# KITTITAS COUNTY

### MEMORANDUM

TO: All Staff  
FROM: Justin Turnbull, County Surveyor   
DATE: October 2, 2017  
SUBJECT: County Survey review of Boundary Line Adjustment 16-00002 (Williams)

DRAWING TYPE **RECORD OF SURVEY**

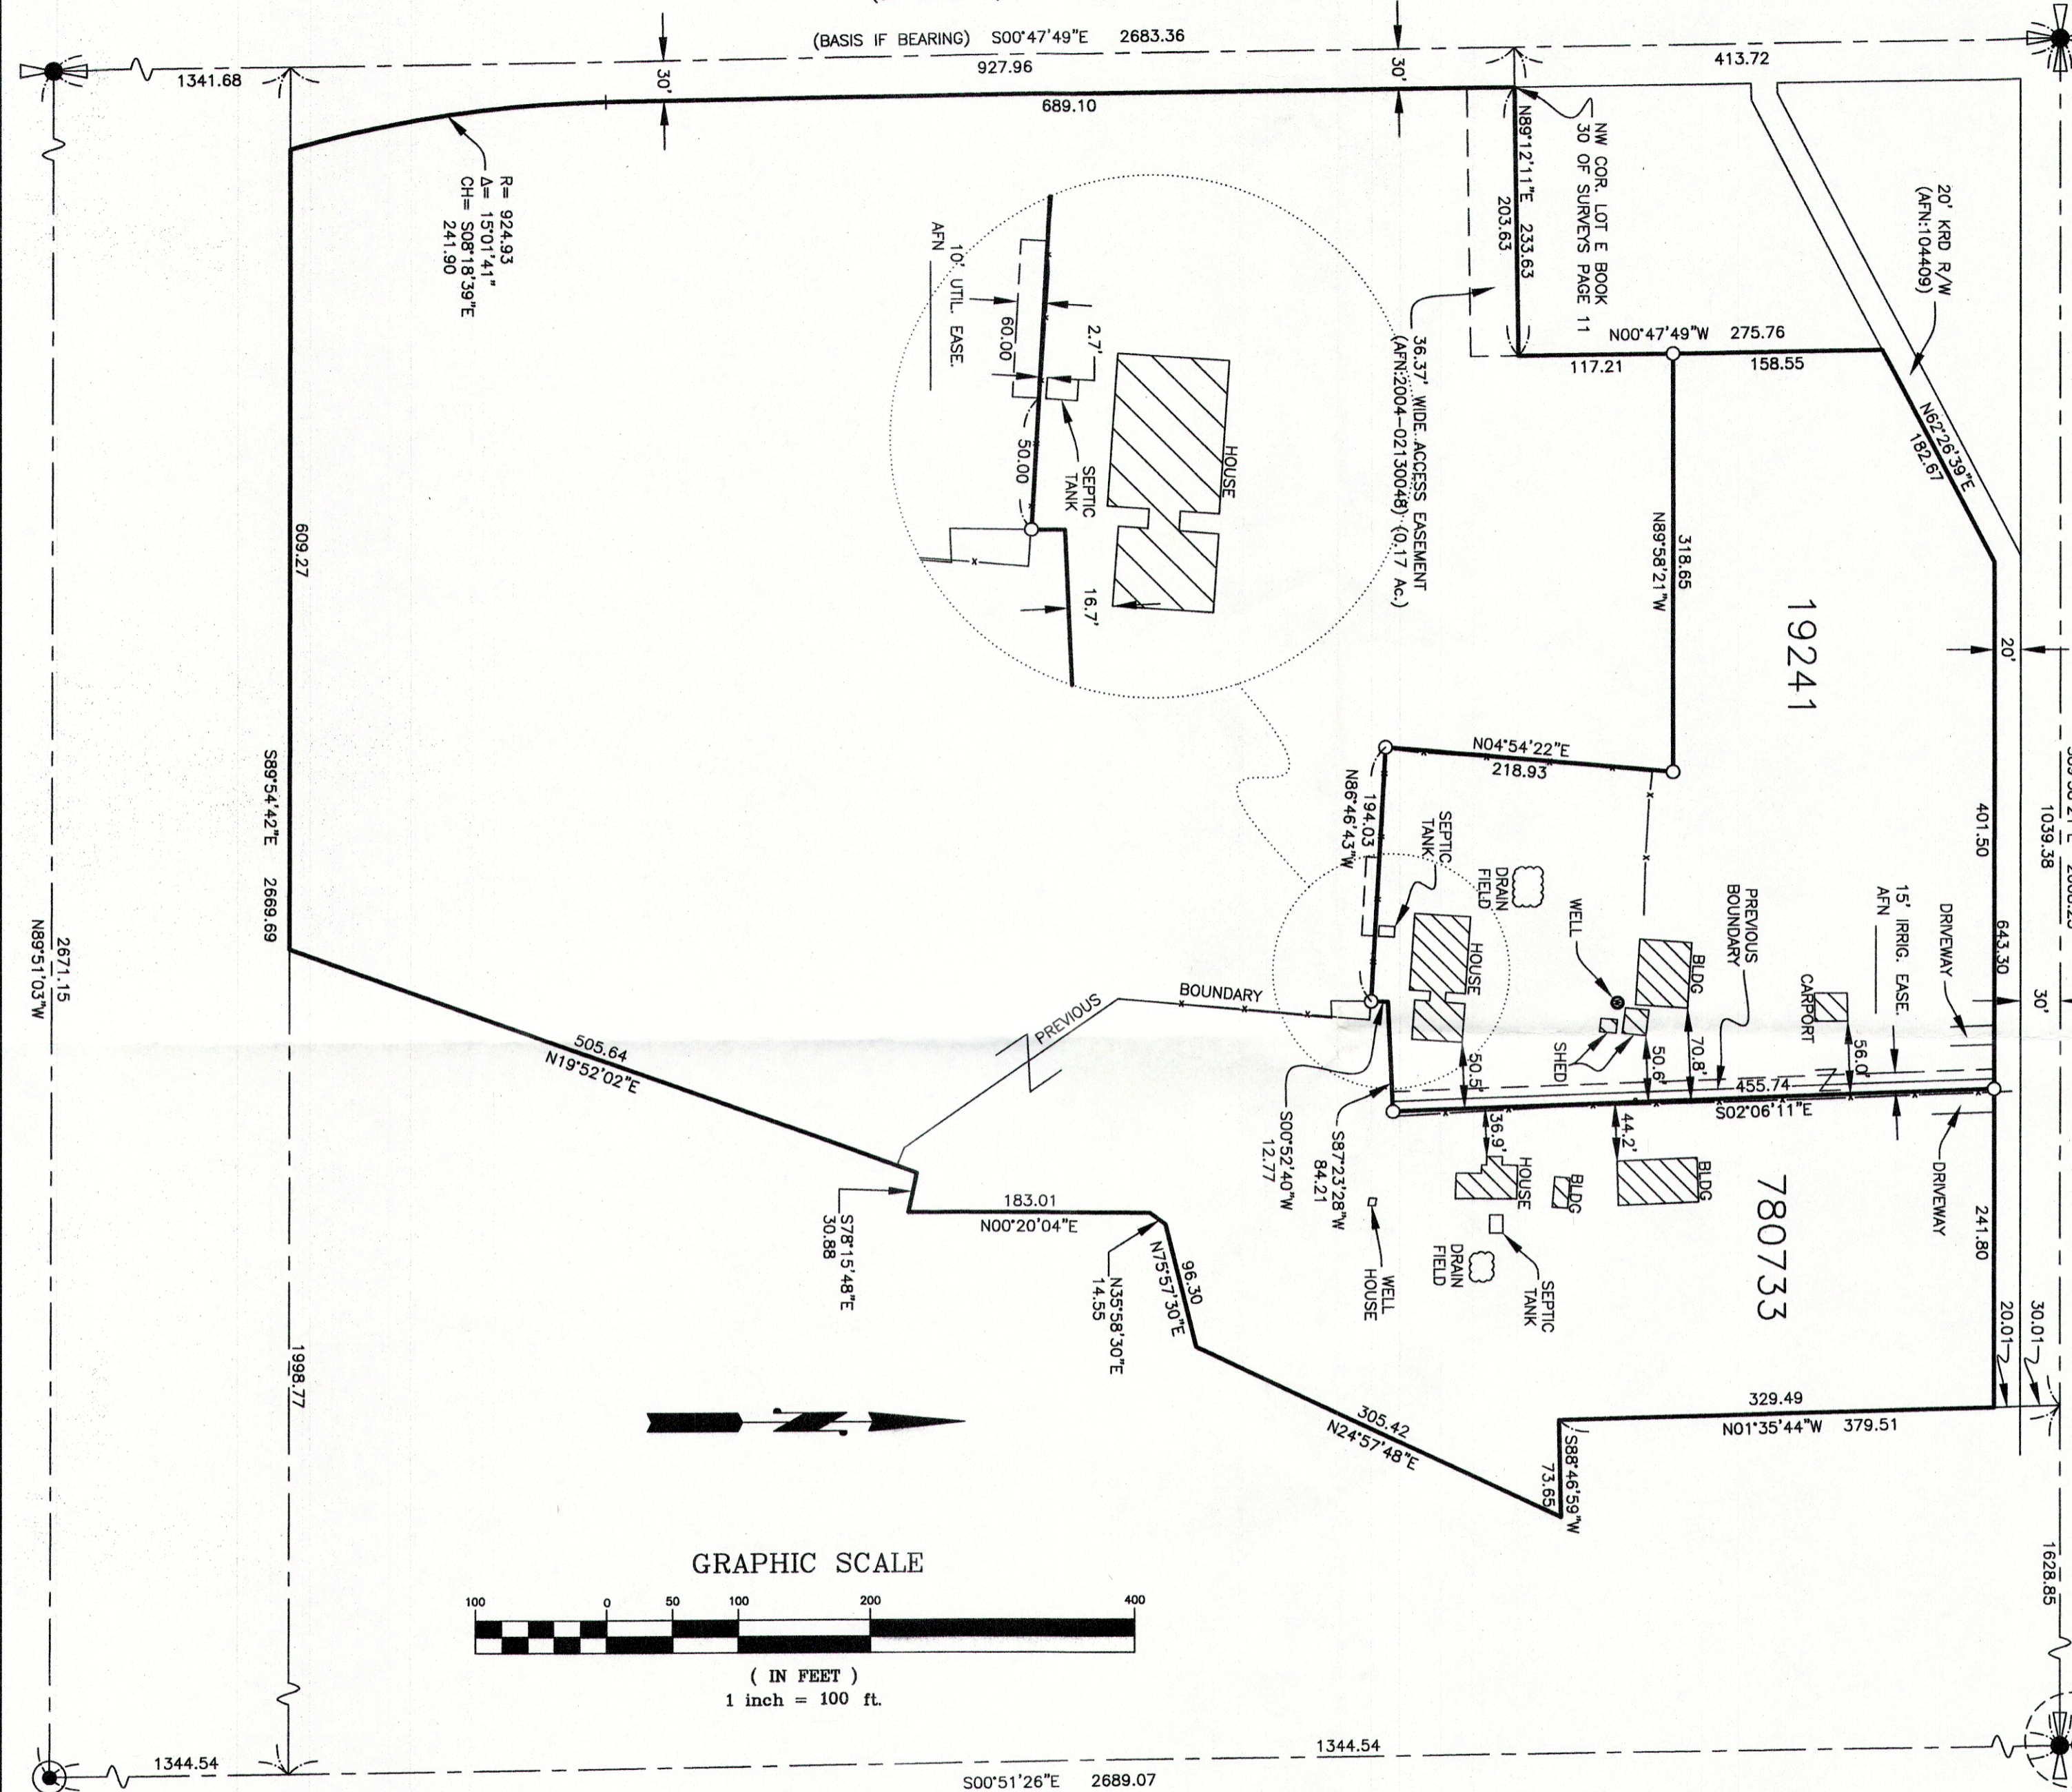
1. Lot areas are not shown.
2. Application number to be included at upper right corner of map. (BL-17-00016).
3. A purpose of survey statement should be shown (purpose of survey is to adjust boundary lines of... to configuration shown hereon)
4. Minor typo in the Basis of Bearing text
